CITY OF ALBUQUERQUE

Re: Montage Units Traffic Impact Analysis, final
Dated October 28, 2021 (HT# R16D099)
Received November 3, 2021
CABQ Planning Transportation comments 11/5/2021

The subject Traffic impact Analysis (TIA) for the Montage Units residential, educational and commercial development dated October 28, 2021 received on November 3, 2021 has been reviewed by the City's Planning Transportation Development Section. The City agrees with the analysis and findings of the study. The following comments should be addressed before acceptance and approval of the TIS.

***Montage Units TIA (Mesa Del Sol)
(Intersection 8: Strand Loop & University Blvd)
(Turn Warrants)***

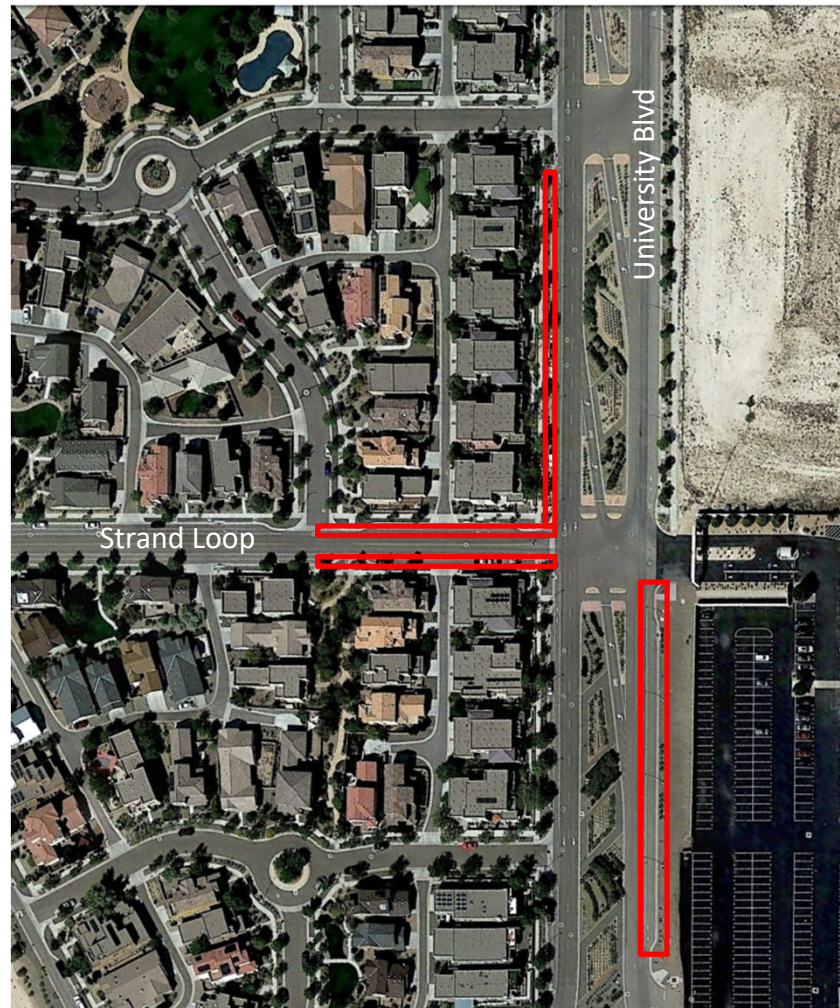
- Arbus Dr and University Blvd. (intersection 11)
 - Eastbound left turn and
 - Southbound right turn
- Strand Loop and University Blvd. (intersection 8)
 - Eastbound left
 - Westbound right
 - Southbound left
 - Southbound right
 - Northbound right
 - Southbound left turn lane, existing
